Application No: BN/38/21/PL
Site Address: Land At Angels Nursery Yapton Road Barnham PO22 0AY
Description of works: Retention of feature entrance wall set back from access to approved residential development at Land at Angels Nursery, Yapton Road, Barnham.

Thank you for your internet representation made on 10th May 2021 which has been recorded as an objection with the comments as follows:

| Drawing Title  |    | SITE_ENTRANCE_FEATURE_WALL_LAYOUT |            |

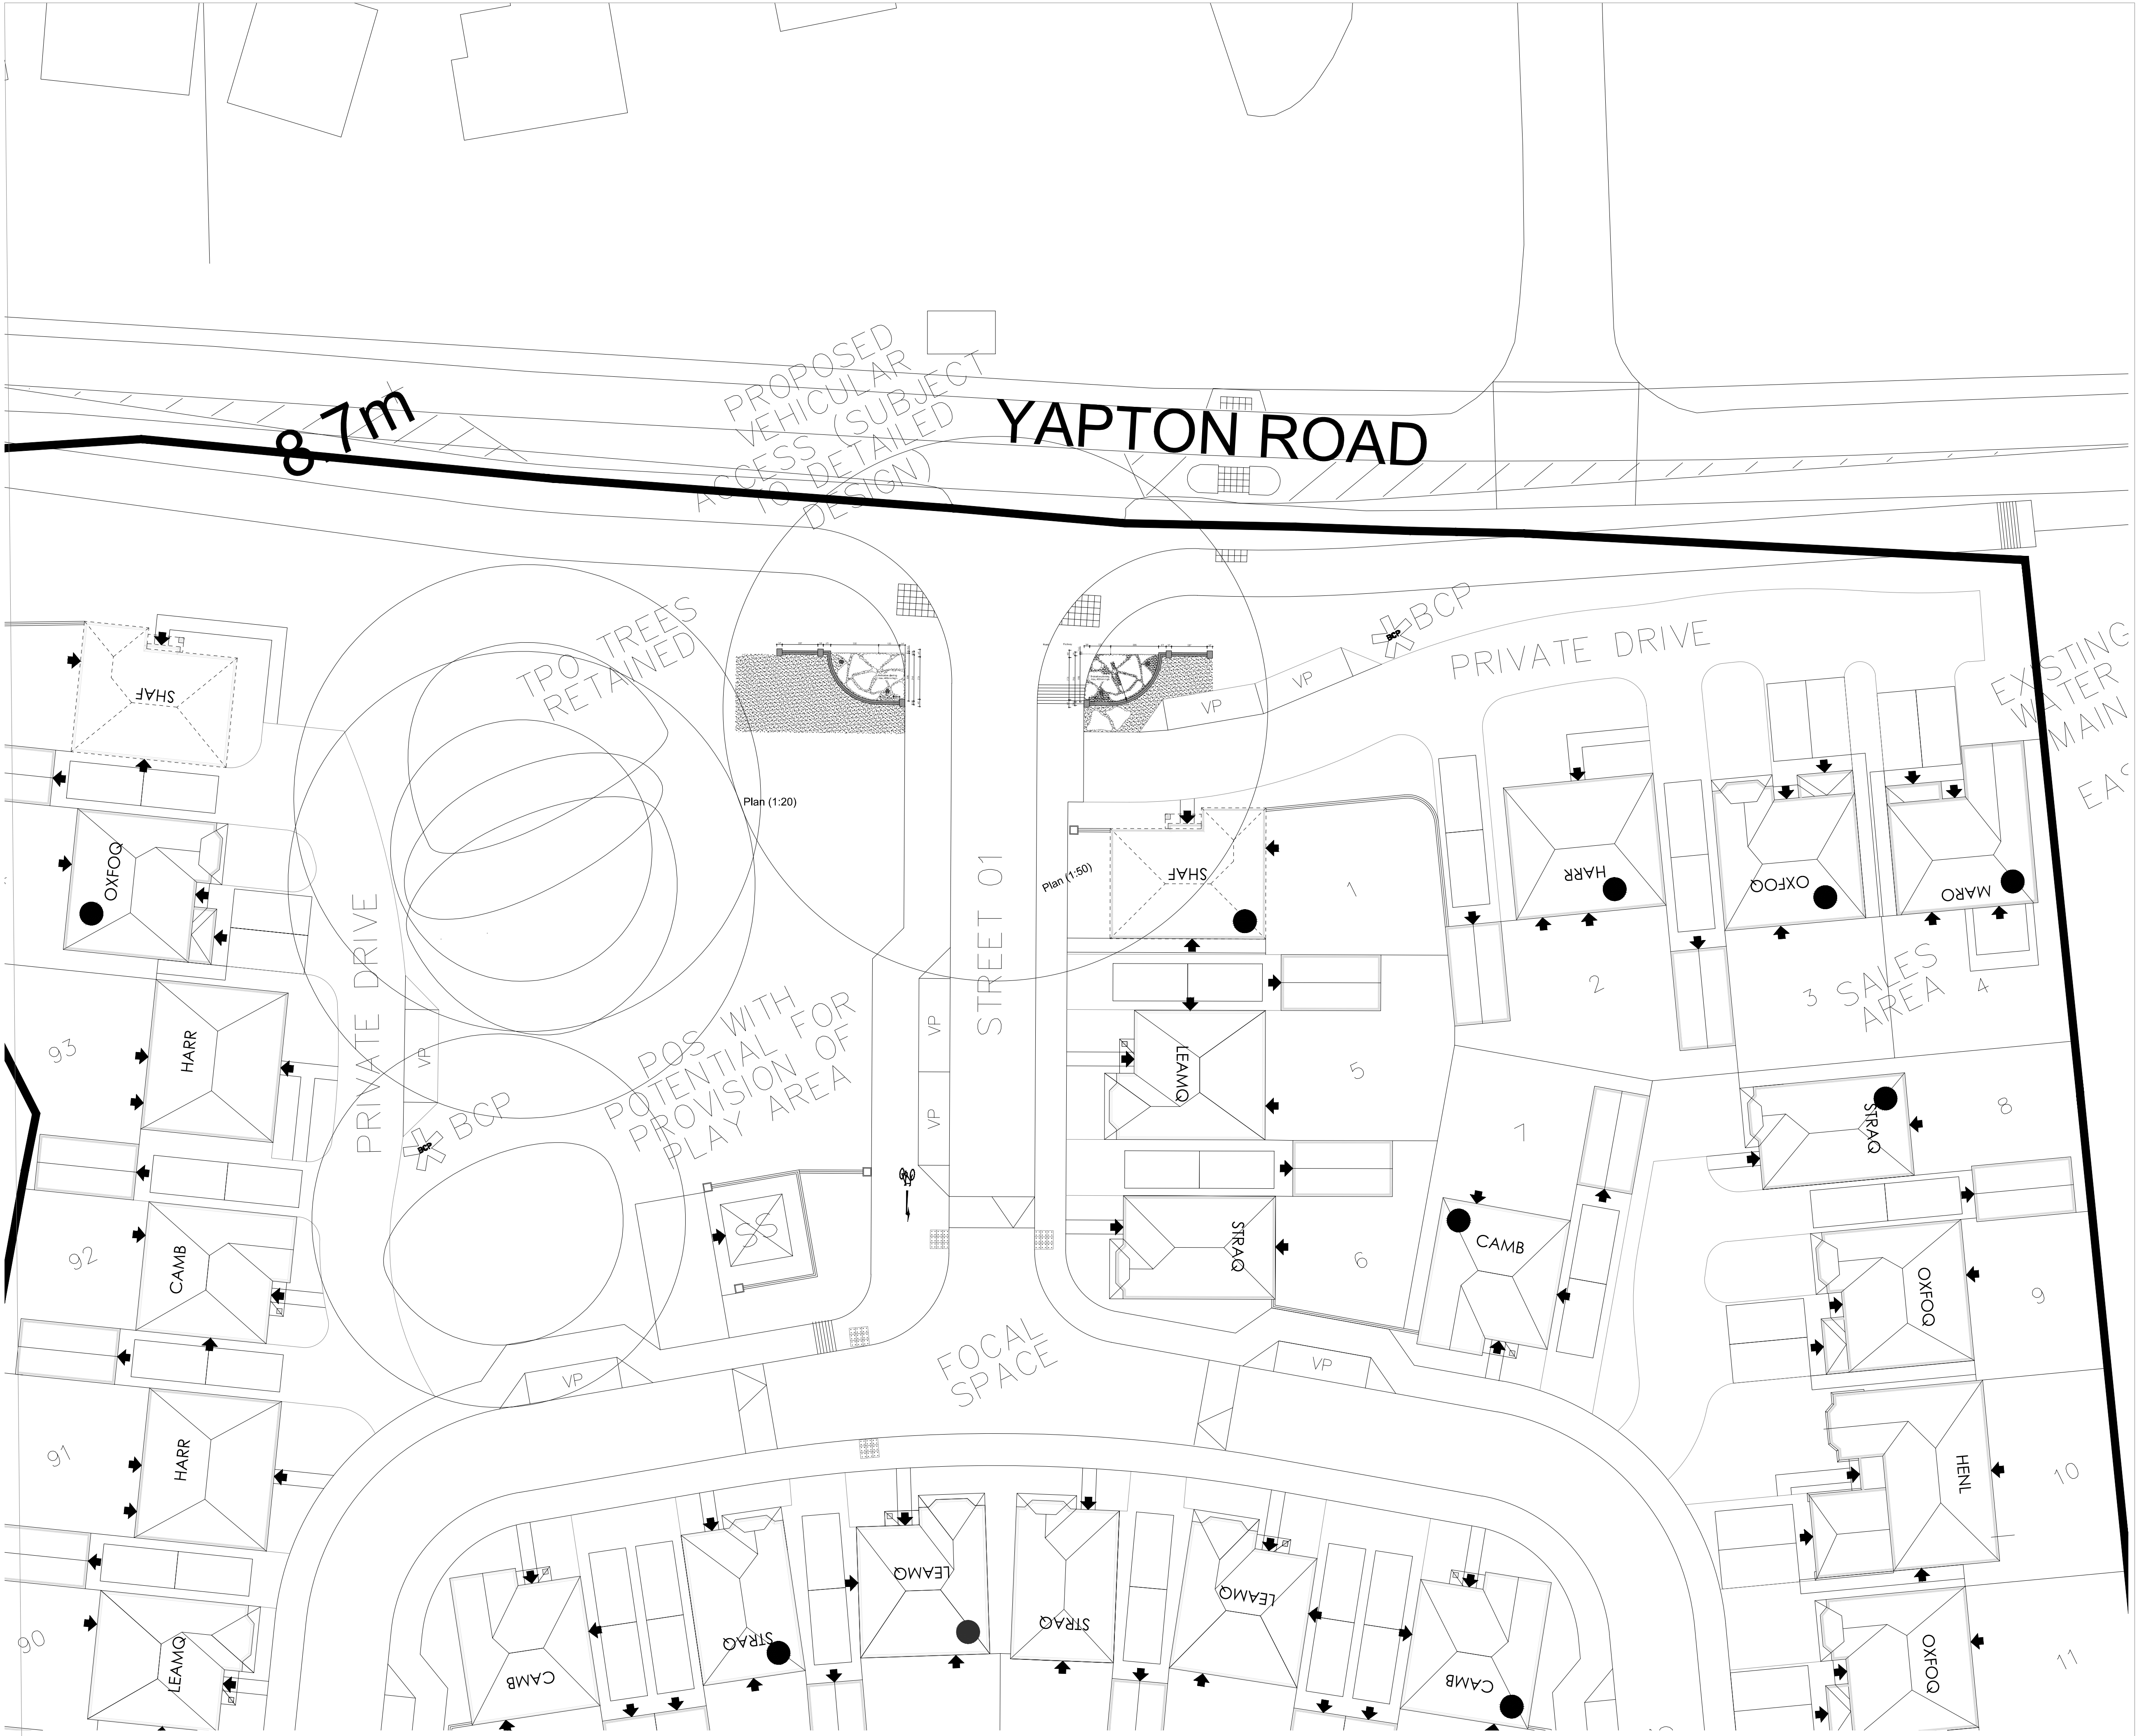
I am registering my anger that this wall has been built prior to obtaining planning permission. The wall was not part of the original plans and in my opinion it changes the character of this development in an adverse way. It is unnecessary, resulting in a false 'entrance' and does not reflect the character of the local area given that it has a suburban design and construction. This is a semi rural area, on the outskirts of a village bordering open countryside, not suburbia, for a harmonious and integrated settlement on Yapton road, we do not want individual housing estates giving themselves pretentious entrances that have the effect of separating them from the whole. Therefore I believe it is out of keeping and should be removed.
